**FRASERS PUTNEY STAGE 1 PHASE 1
APARTMENT BLOCK 1**

ACCESS REVIEW

Morris Goding Accessibility Consulting

16th April 2012

| Drawing Title<br>APARTMENT PLANS                            |                   |                    |           |

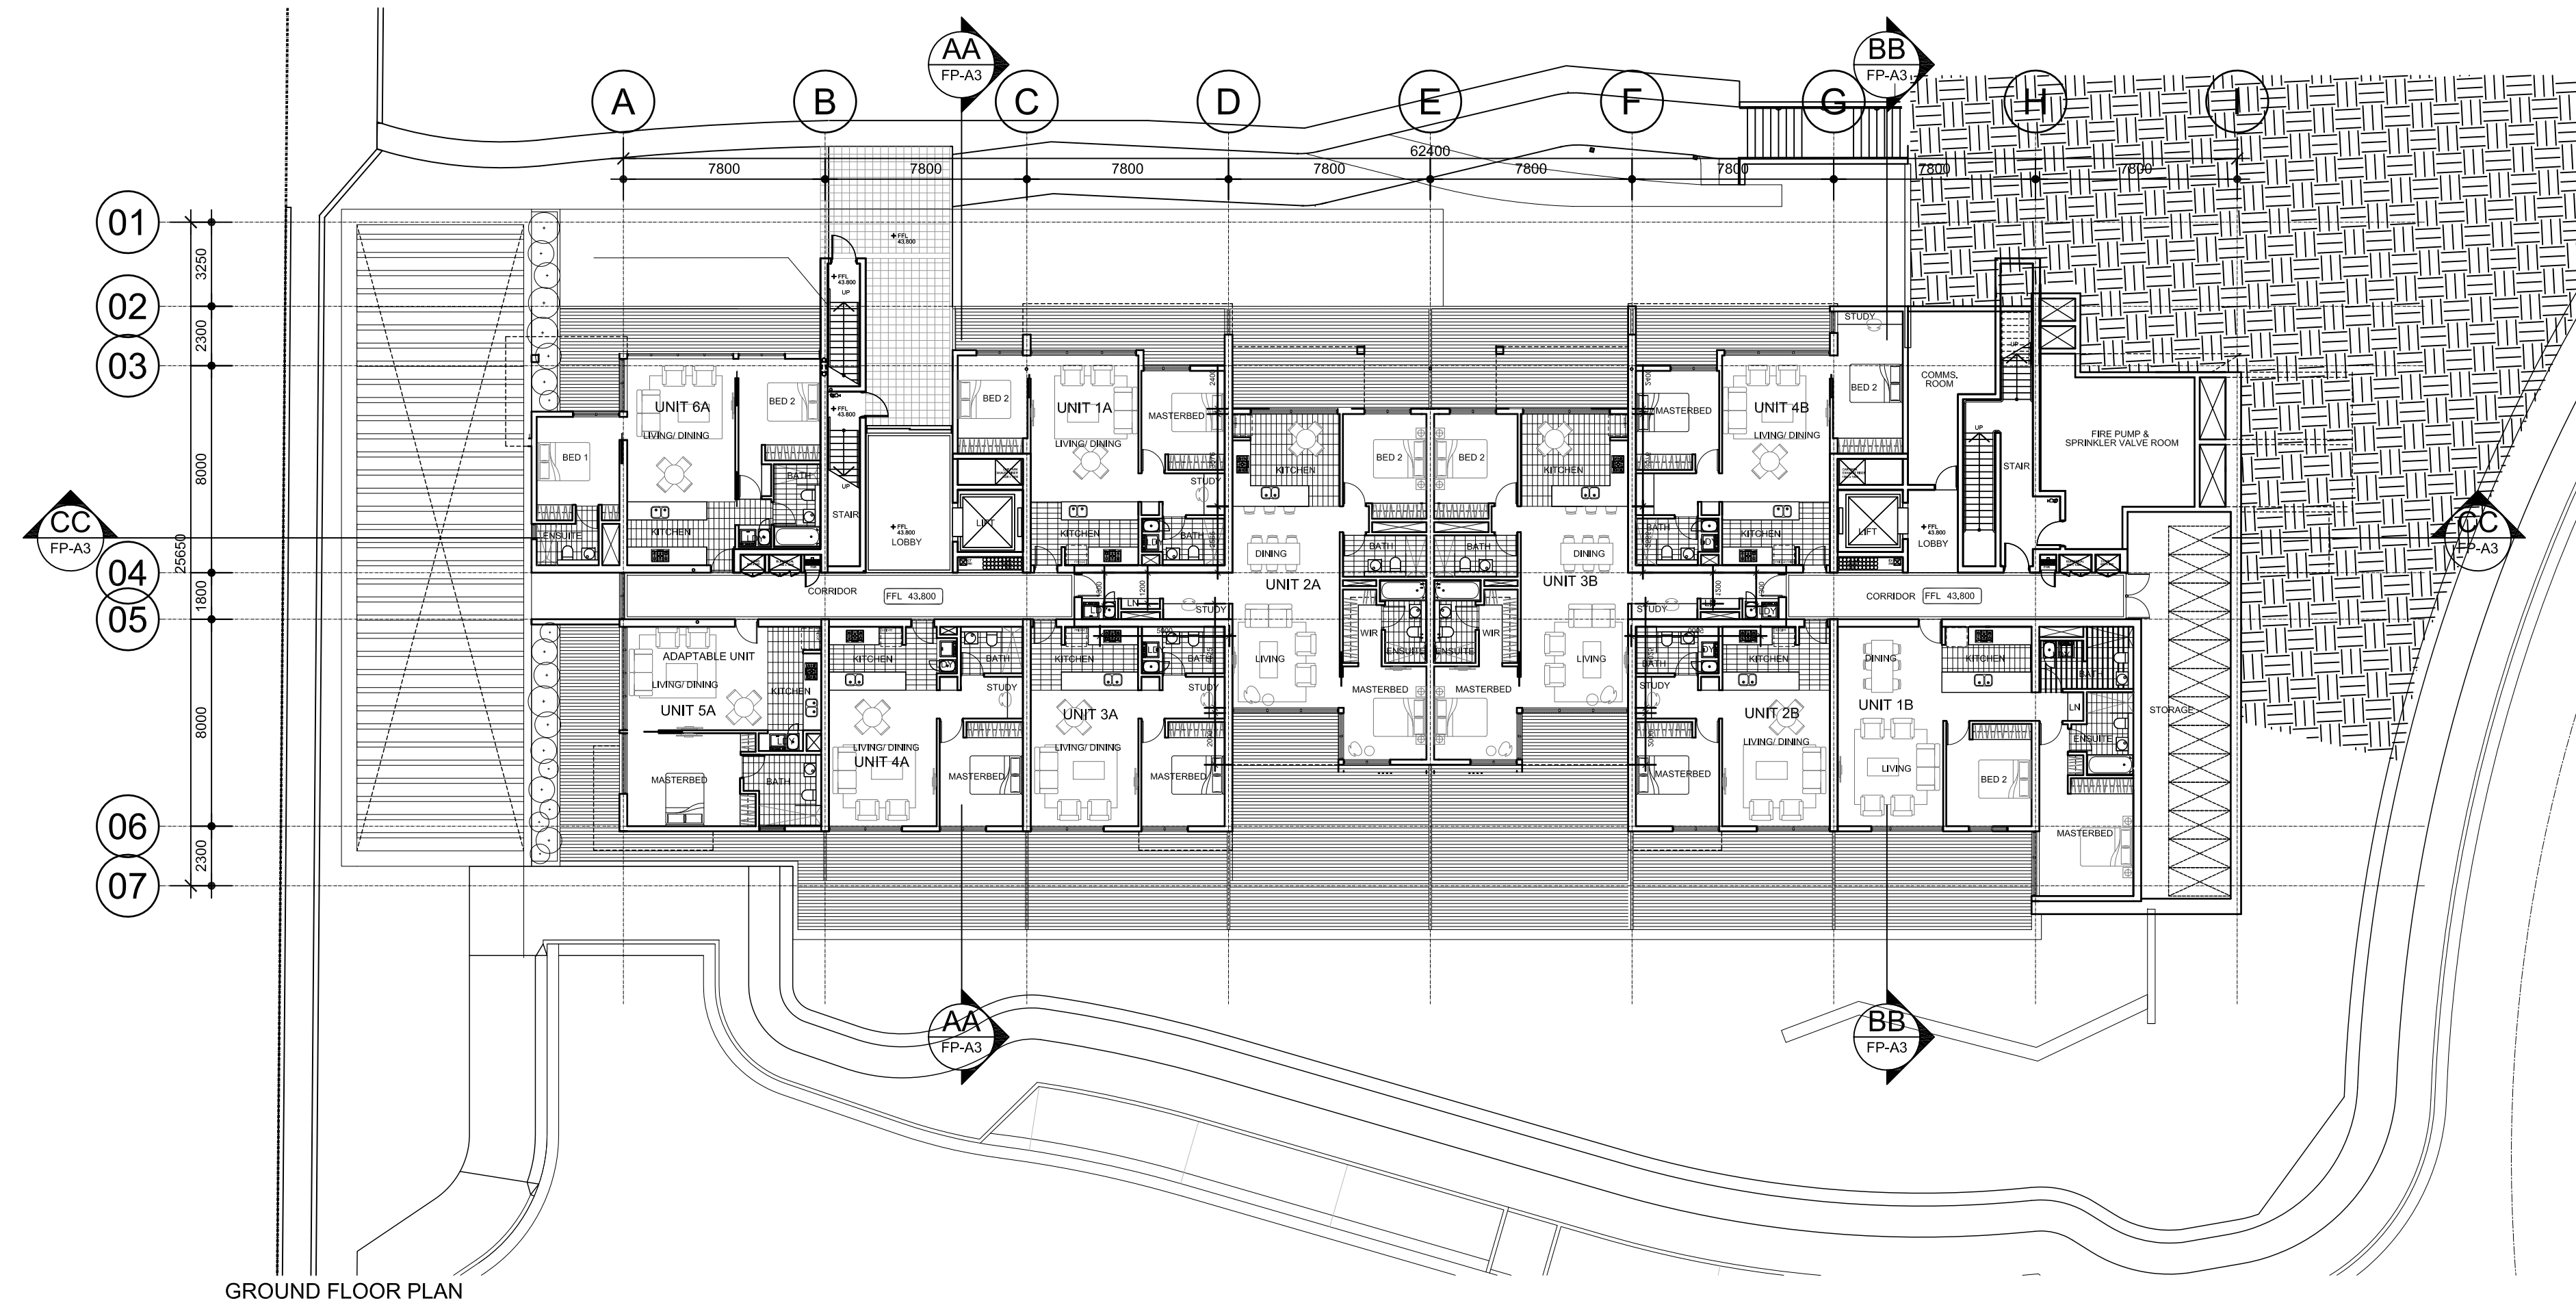
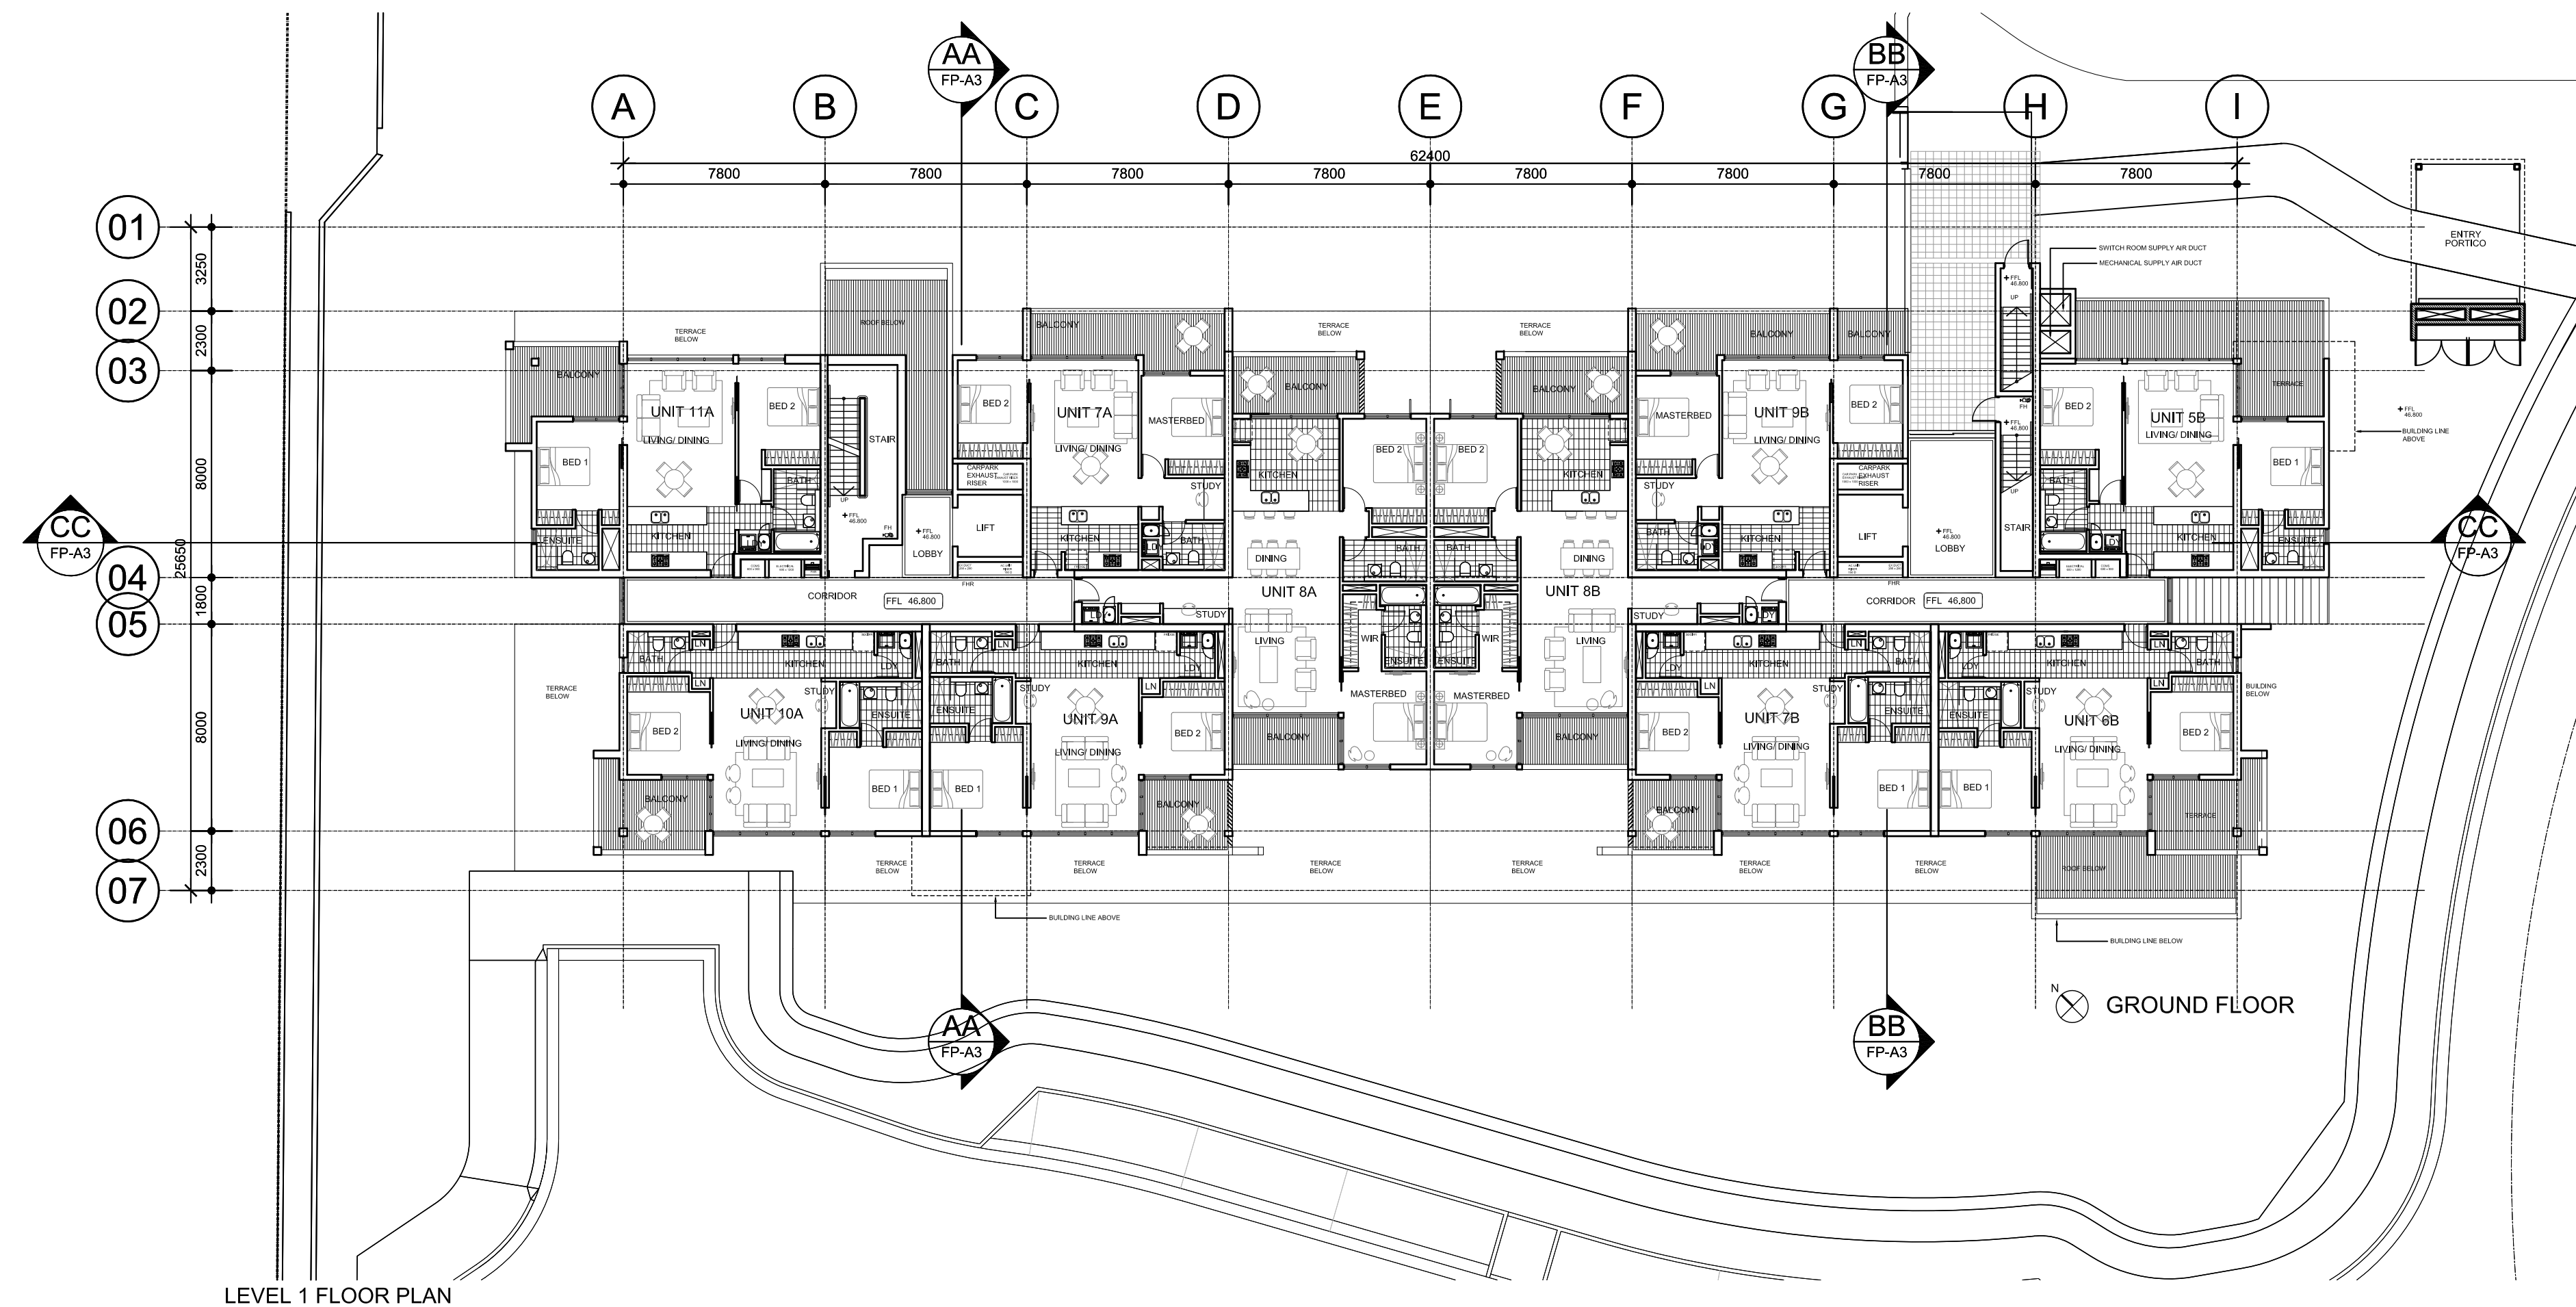
- (i) Ensure an accessible path of travel from the pedestrian footpath to Block 1 main entrance doors at ground level, compliant with AS1428.1:2009 and AS4299.
- (ii) Ensure the active leaf of main entry doors provide at least 850mm clear width compliant with AS1428.1:2009 and AS4299.

- (i) Ensure an accessible path of travel from the pedestrian footpath to Block 1 main entrance doors at lower ground level, compliant with AS1428.1:2009 and AS4299.
- (ii) Ensure external stairway is recessed at top and bottom to allow for appropriate handrail extensions, compliant with AS1428.1:2009.
- (iii) Provide handrails on both sides of the external stairway, compliant with AS1428.1:2009 and suitable reinforcement to support stair platform lift.
- (iv) Ensure the stair platform lift is compliant with AS1735.7 and BCA Part E3.6.
- (v) Ensure the active leaf of main entry doors provide at least 850mm clear width compliant with AS1428.1:2009 and AS4299.
